**MODIFICATION REQUEST:**  
**Residential Subdivision**  
**Belle O'Connor Street, South West Rocks**  
**08\_0167 MOD 1**

Director-General's  
Environmental Assessment Report  
Section 75W of the  
*Environmental Planning and Assessment Act 1979*

August 2013

Figure 3 – The Part 3A approved subdivision.

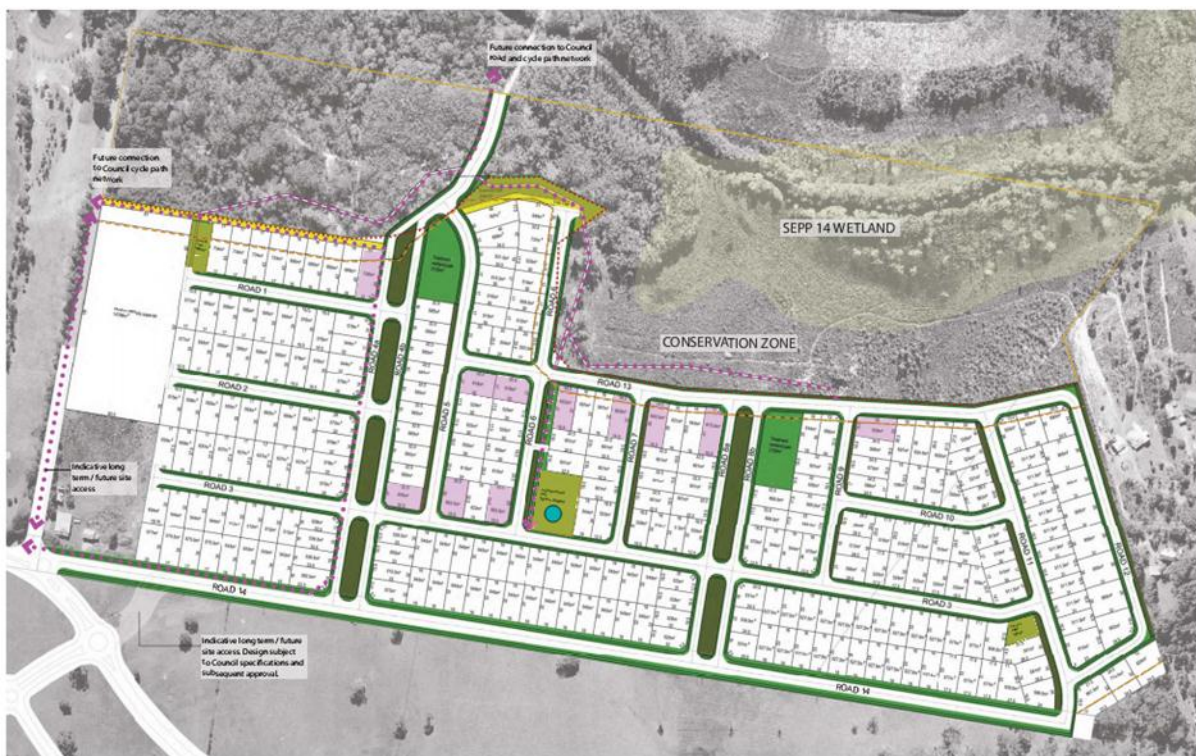
Council raised a number of concerns regarding the redesign of the stormwater treatment train, including consistency with the Saltwater Stormwater Management Strategy (BMT/WBM 2007), appropriateness of planting out the bio-retention swales, the impact of a high water table, gross pollutant pre-treatment, the impact of locating vegetated swales in the road reserve and appropriateness of the grass swale approach on a site with a grade of less than 1%.

The proponent responded to the issues raised by council, which was subsequently forwarded to council for review. Council's response indicated that their only outstanding primary concern was the departure from the Bioretention Technical Design Guidelines. In particular, the insufficient longitudinal gradient combined with high seasonal water table and the lack of site-specific water sensitive urban design.

With respect to concerns regarding water quality and impacts on the downstream wetlands, the department has considered the concerns raised by council and the advice from the proponent's consultant and is satisfied that the amendments proposed as part of the revised stormwater management regime involving the deletion of stormwater treatment wetlands and piping of inter-allotment drainage, will not impact on the adjoining or downstream environments. It is considered that sufficient measures are proposed to be implemented as part of the revised stormwater drainage regime to ensure appropriate treatment occurs in place of the constructed wetlands, including bio-retention swales containing broad leaved native plant species for evapotranspiration processes to occur, and additional bio-retention area along the northern periphery of the site. The revised stormwater management regime for the site is therefore supported.

JOB NO : 4972_N_SHT 03
ISSUE: B
DATE: 5.04.2013

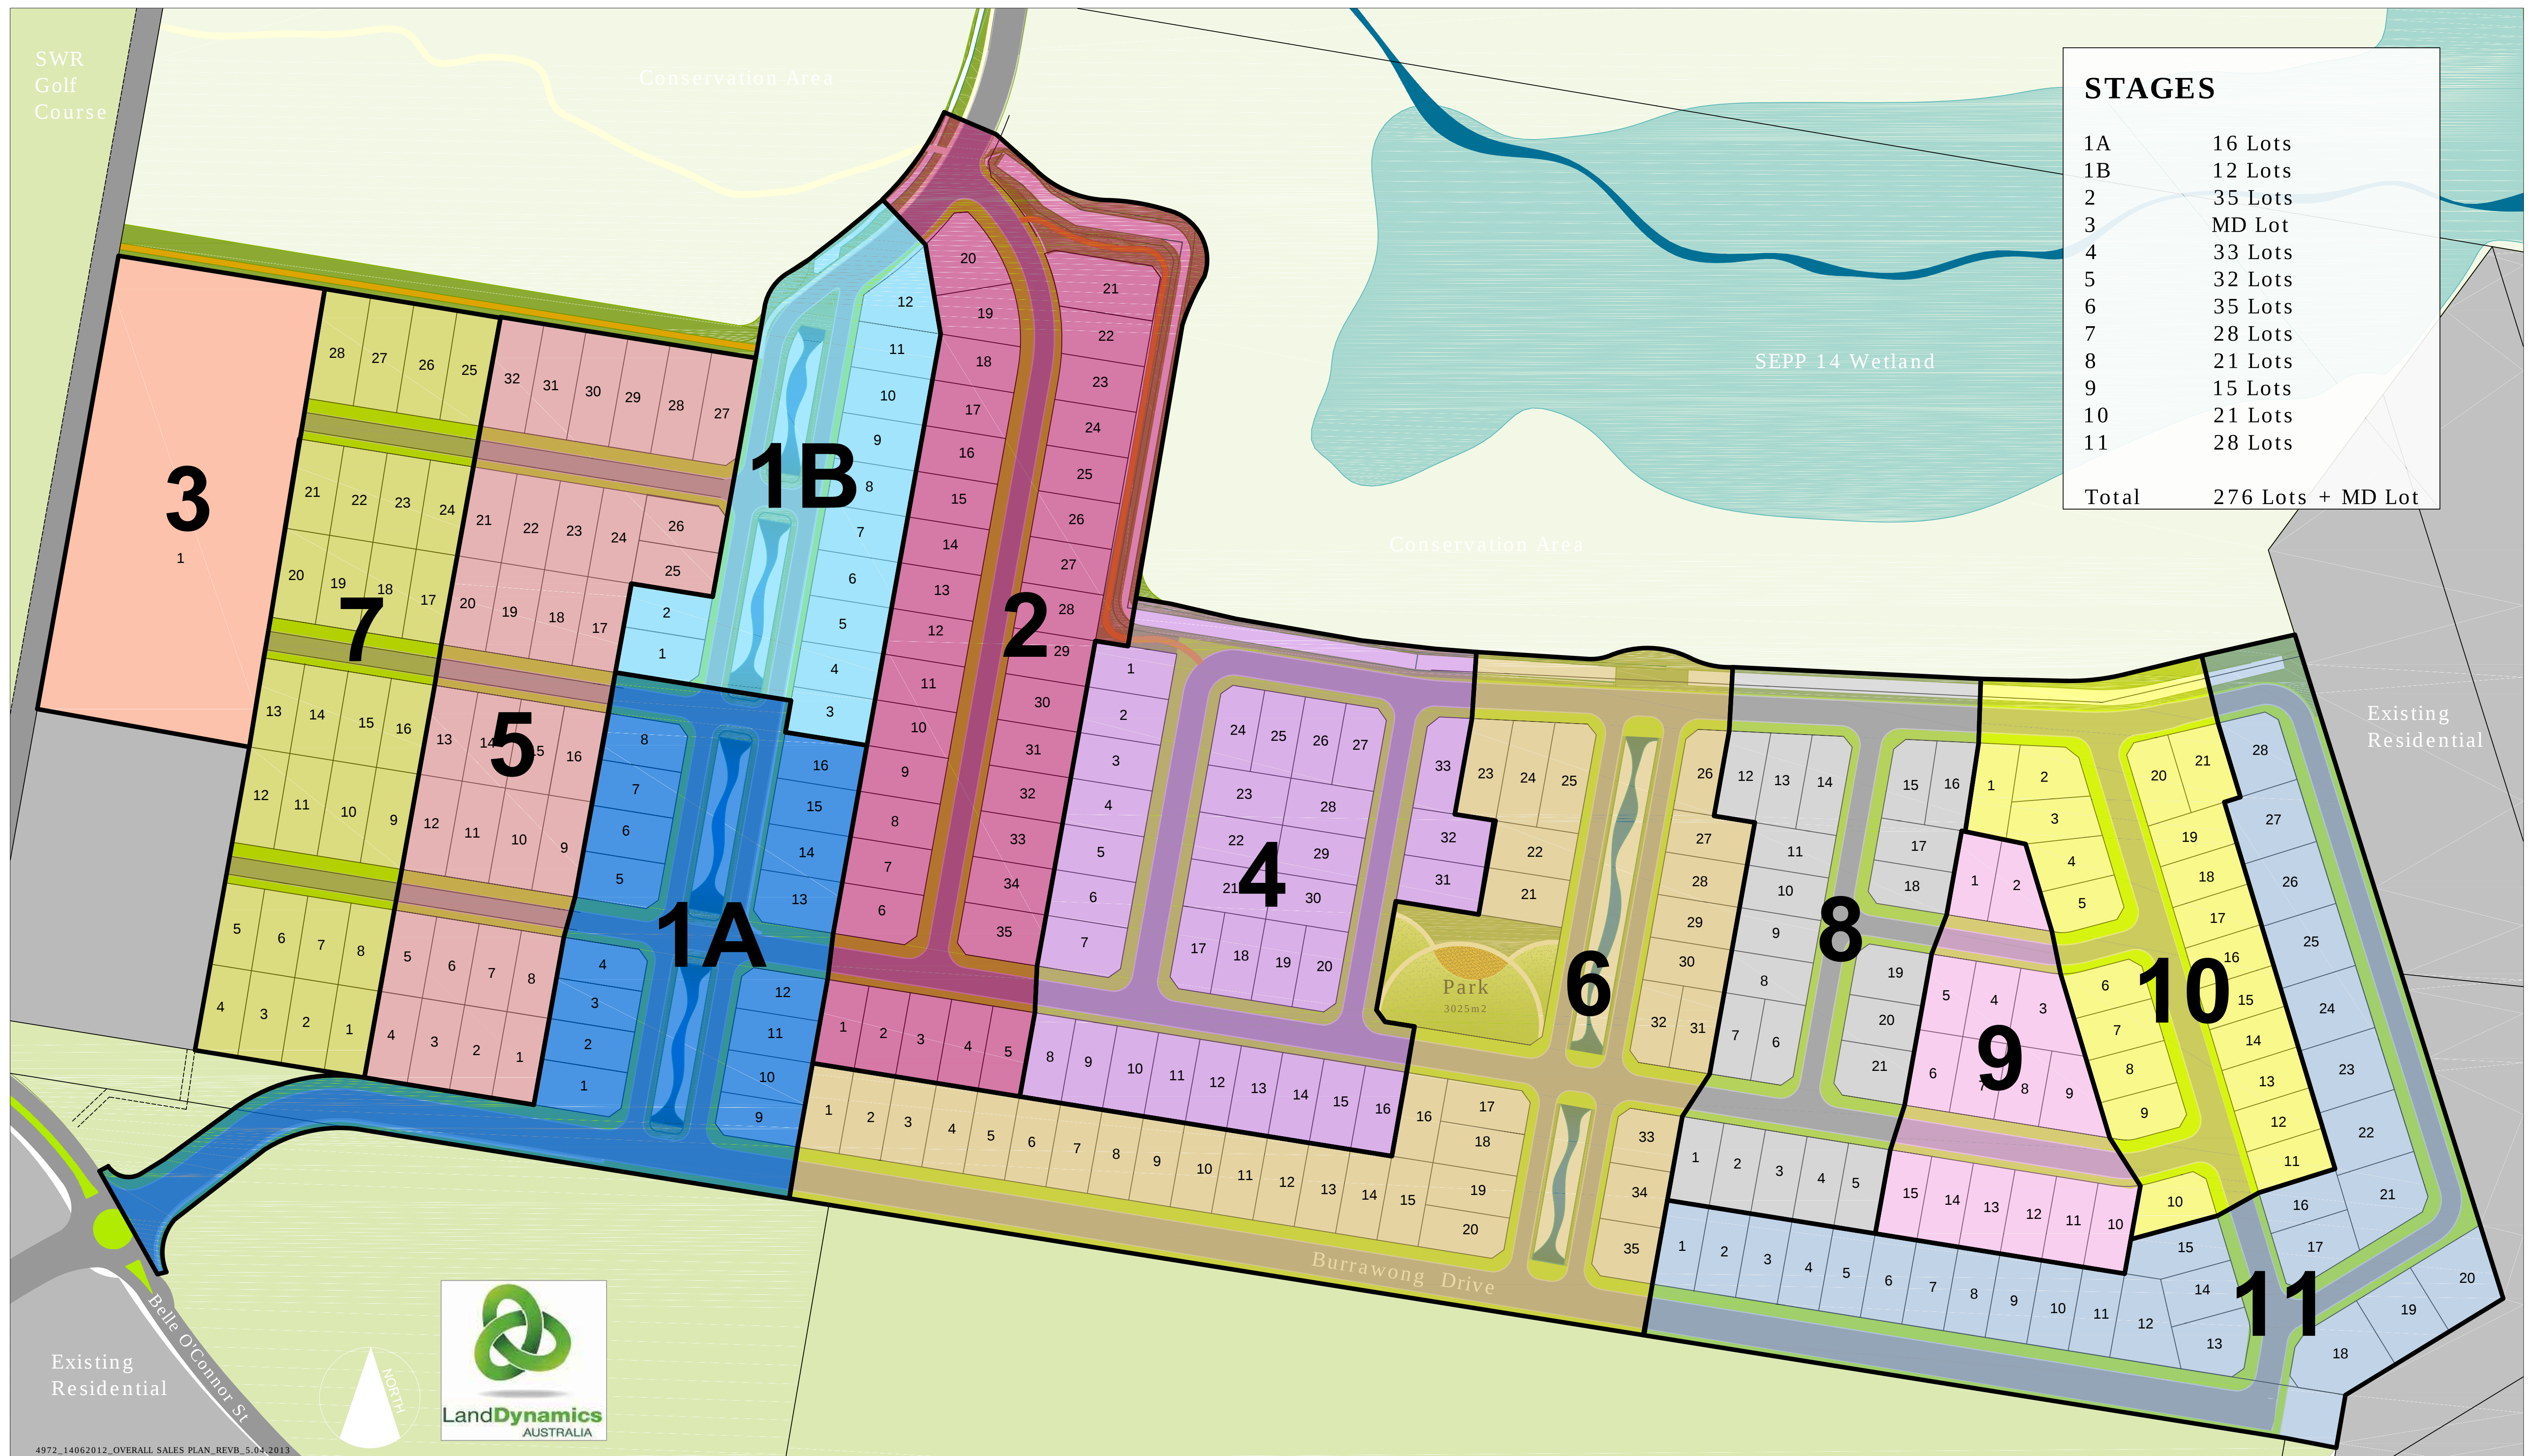
The modification application originally sought to delete both the stormwater treatment wetlands and the exercise park. The department and council raised concern with the proposed deletion of the exercise park as this would significantly reduce the amount of public open space to service the future population of the site, particularly as the stormwater treatment wetlands (to be used intermittently as passive open space) are also proposed to be deleted.

The proponent subsequently submitted a revised subdivision plan which proposes to increase the central active open space park from 3,025m<sup>2</sup> to 4,470m<sup>2</sup> in area. In addition, the bushland exercise park (initially proposed to be deleted) is now proposed to be retained as part of the subdivision, albeit reduced in size from 2,481m<sup>2</sup> to 1,450m<sup>2</sup>. In total, the revised proposal includes 5,920m<sup>2</sup> of active open space, which is a 414m<sup>2</sup> increase compared to the approved development (excluding the stormwater treatment wetlands, which were proposed to intermittently act as passive open space). The revised subdivision design showing the location of public open space is provided at **Figure 7** below.

Council advised that the revised public open space provision is an acceptable outcome for the site. The department is satisfied that the revised proposal provides sufficient public open space that is generally consistent with both the size and location of public open space approved as part of the original proposal.
